EPC STORMWATER REVIEW COMMENTS
IN ORANGE BOXES WITH BLACK TEXT

CITY LINK TRUCKING

Grading & Erosion Control Plans

El Paso County, Colorado

HORZ. SCALE: 1"=30'	DRAWN: PV
VERT. SCALE: N/A	DESIGNED: JPS
SURVEYED: COMPASS	CHECKED: JPS
CREATED: 08/29/22	LAST MODIFIED: 09/06/23
PROJECT NO: 052301	MODIFIED BY: PV
SHEET:	C1.1

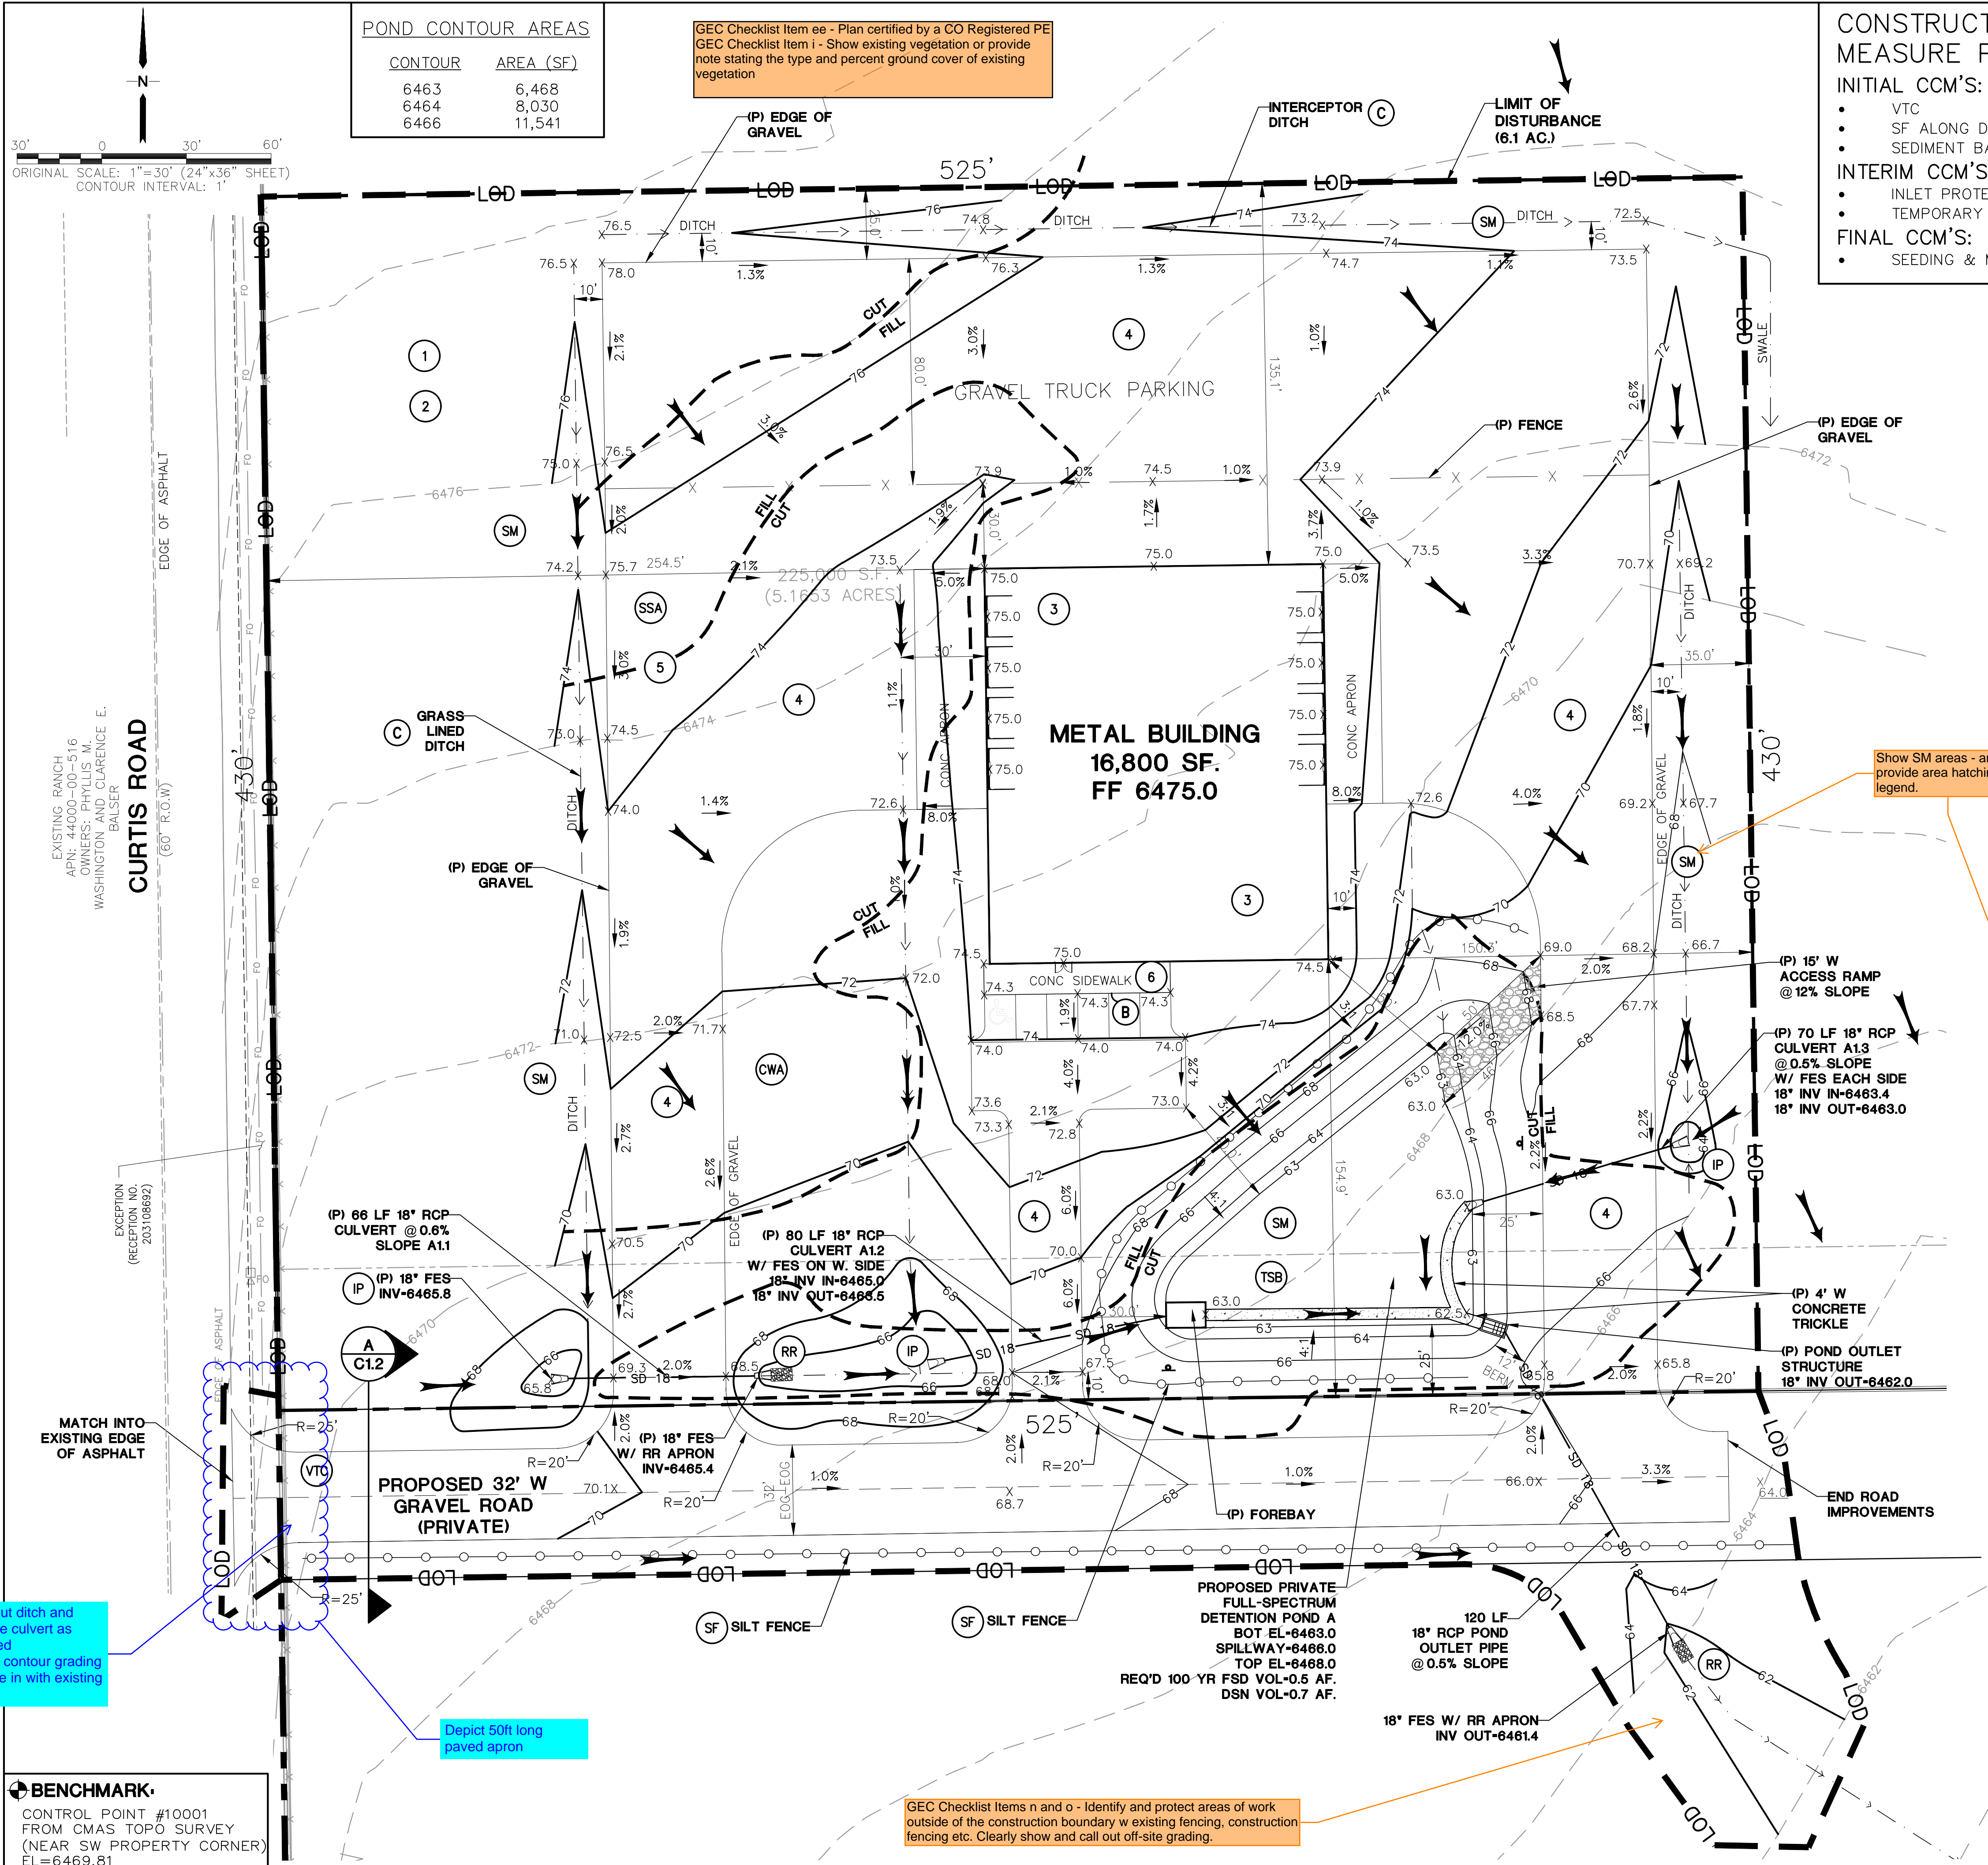
provide plan and profile of the proposed roadway. Note that roadways whether public or private shall meet County standards.

The Site plan indicates driveway, if the intent is to construct a roadway, the location of the 3 proposed driveways will need to meet spacing requirements indicated in ECM 2.4. Due to the minimal traffic identified in the previous TIS for this first phase of the development the roadway would be classified as a rural local road (25mph posted speed). The location of the proposed driveways would not meet criteria. Please revise the proposed locations to meet criteria.

If proposing a roadway as shown in these CD's consideration should be given to the ultimate classification of the roadway as the proposed access points may need to change to meet County criteria especially if in the future it is planned for this roadway to be public.

Correct grading contours and provide more offset from road, ditch and pond. These depressions and pond are in the middle of the road

Where is overflow runoff? A culvert appears to be missing

the location of this outfall pipe does not match the drainage plans. Revise accordingly so that they are consistent with each other.

TYPICAL PARKING / ACCESS DRIVE SECTION (B)

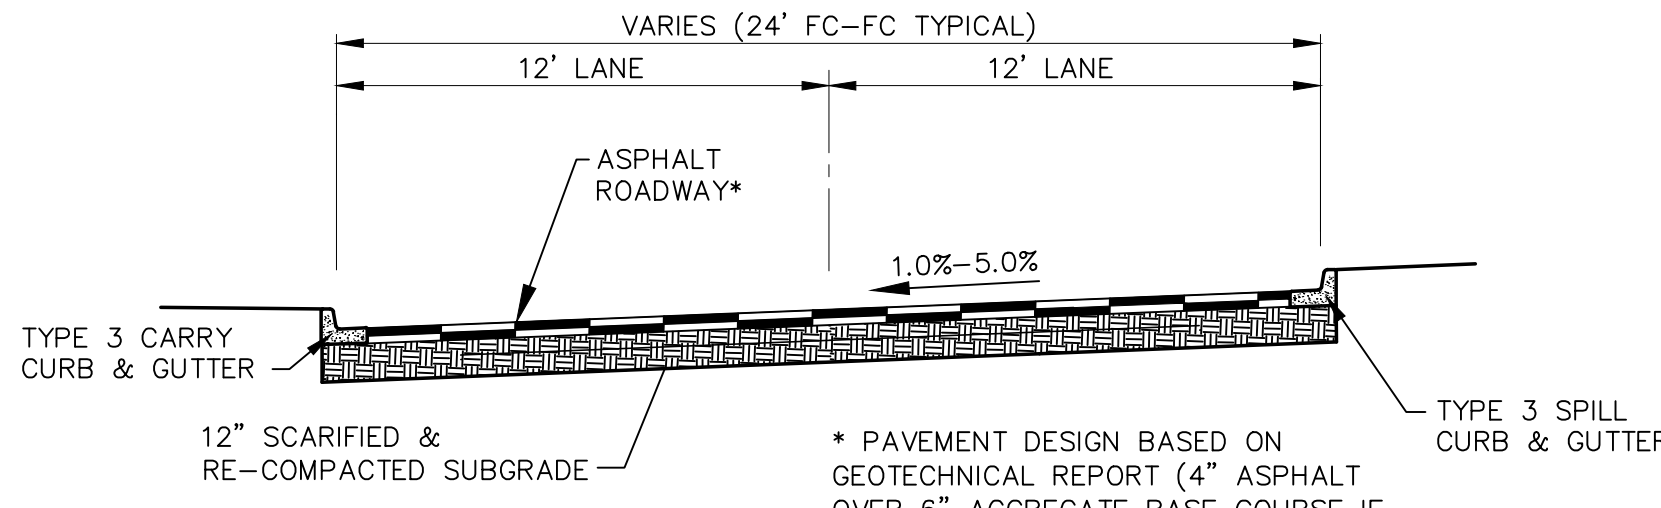
the site plan indicate gravel access drives on two of the driveways. Revise accordingly and label the c/g on the plans
